ENG-PUDSP21002-R1-PDR.pdf Markup Summary

21-002

Also see comment letter.

SP01

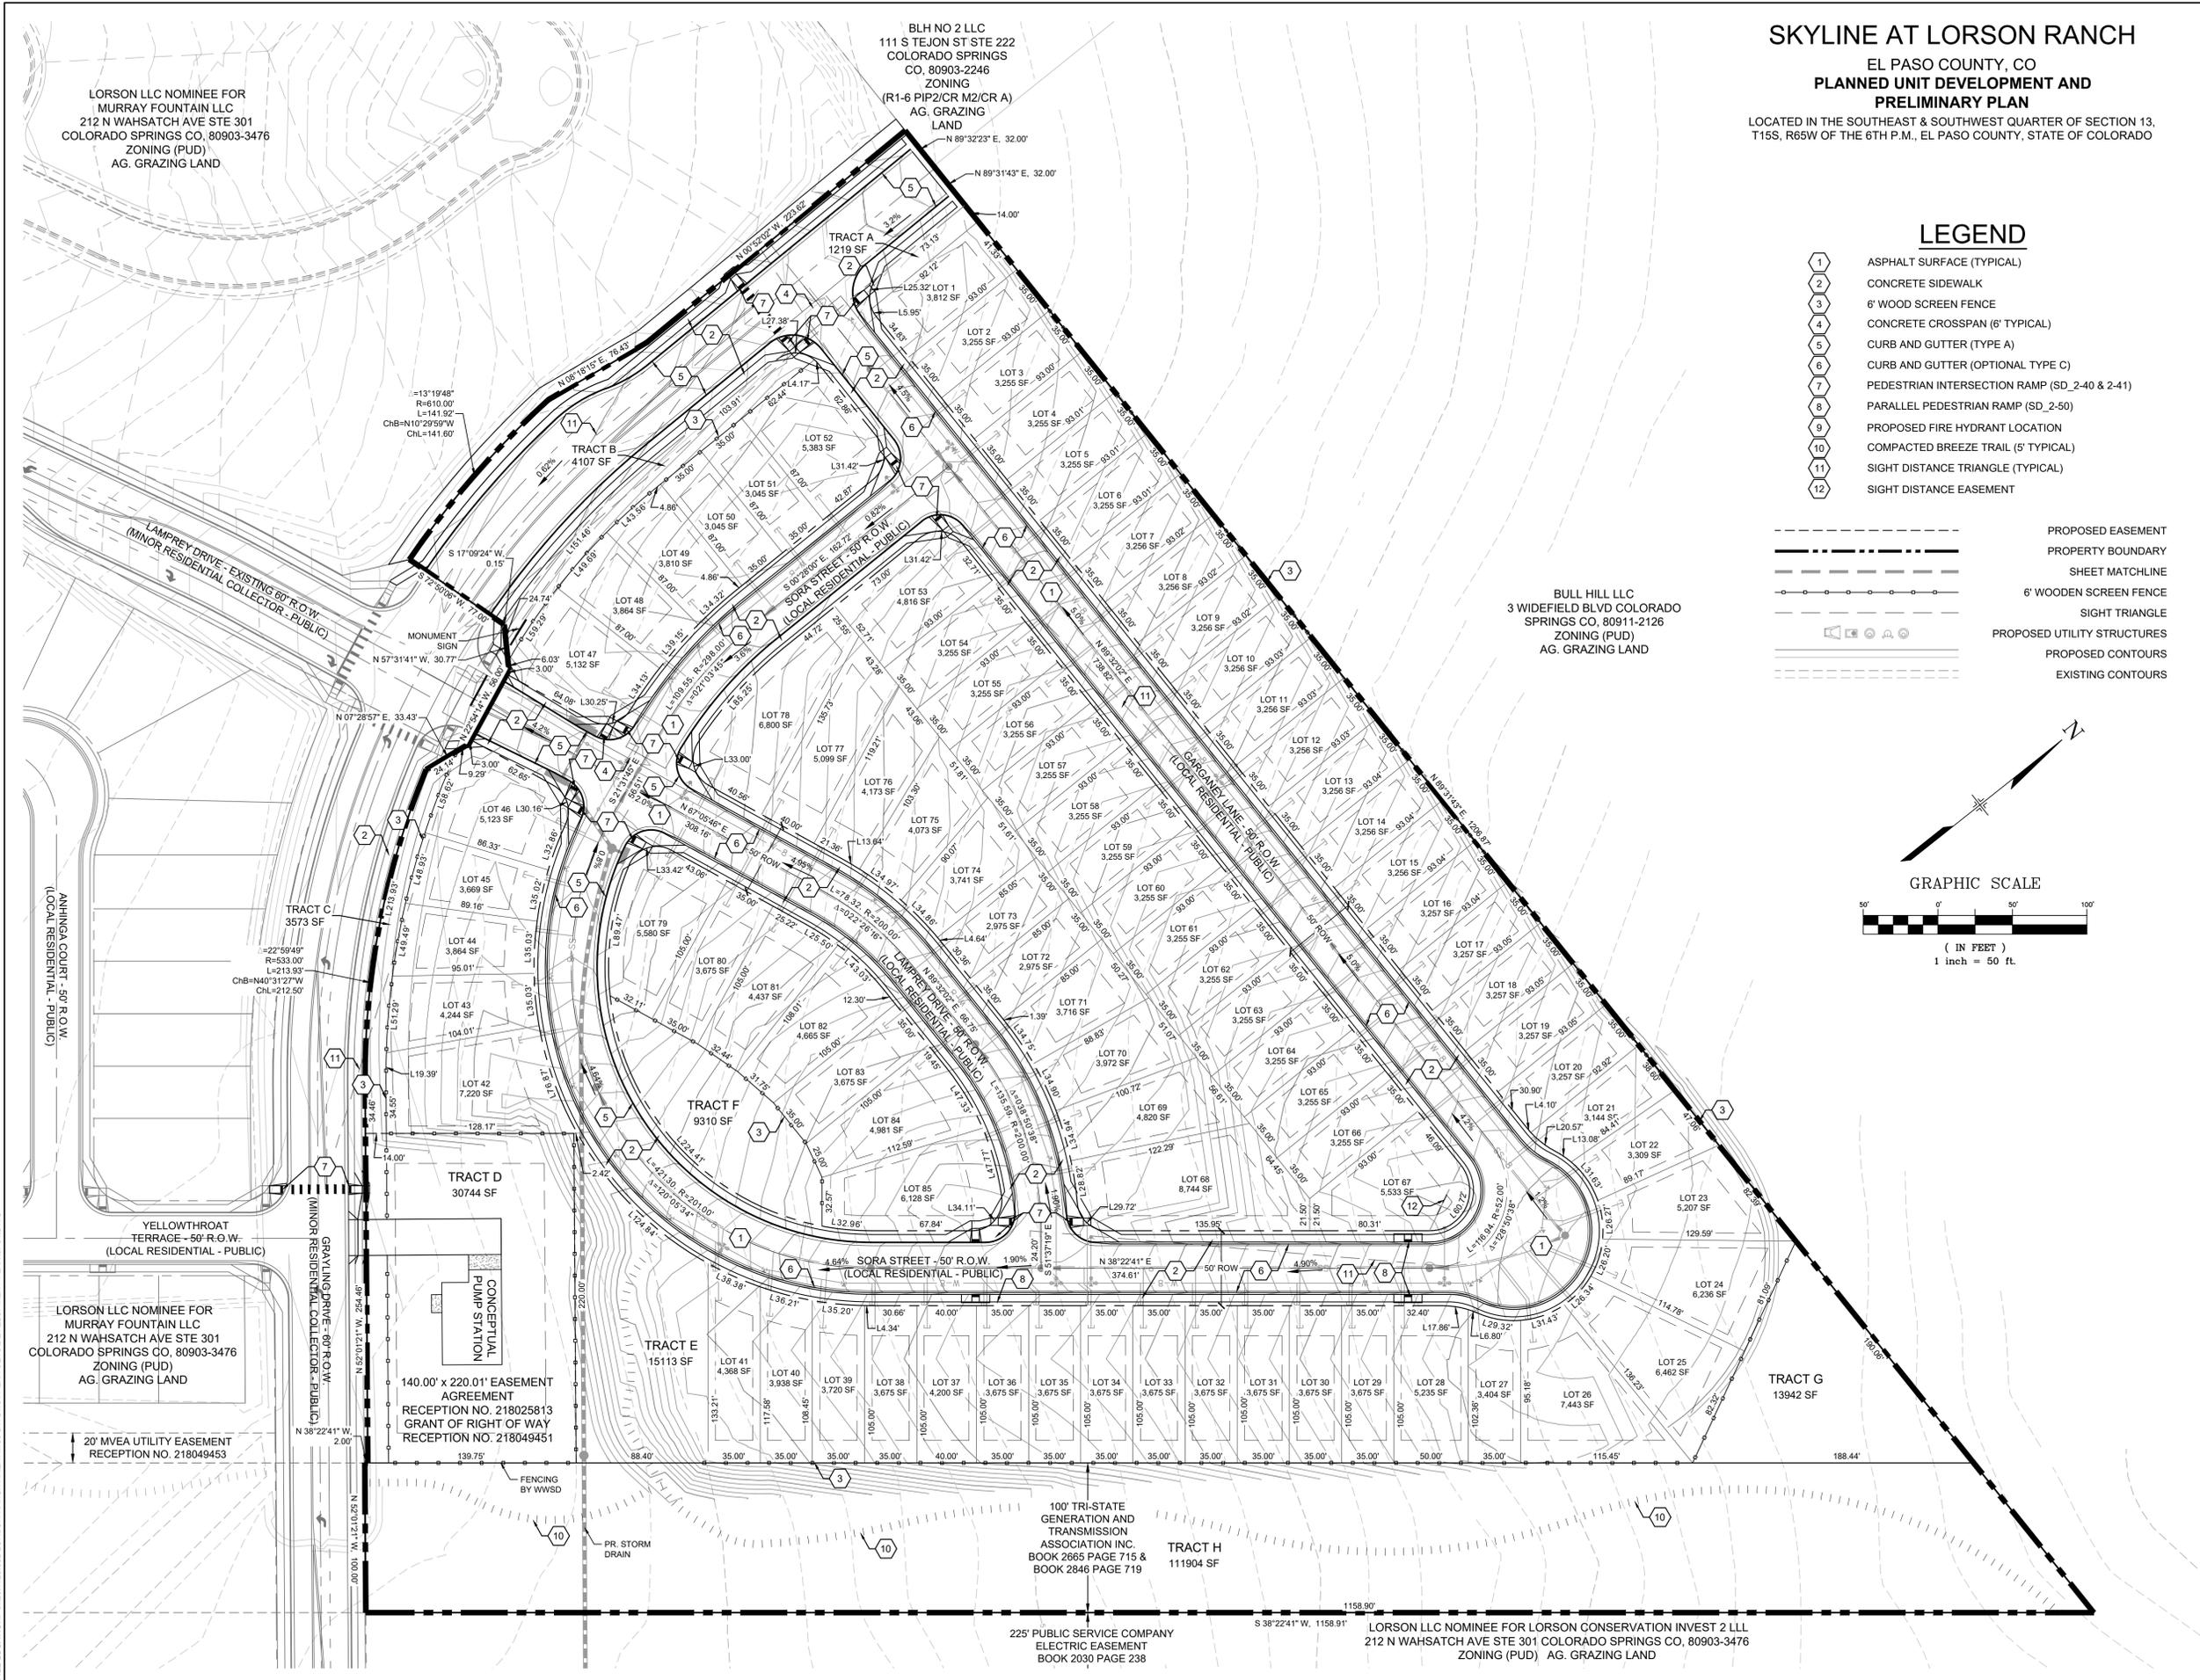
show the pond contours as existing

Provide a tract for Pond C4.
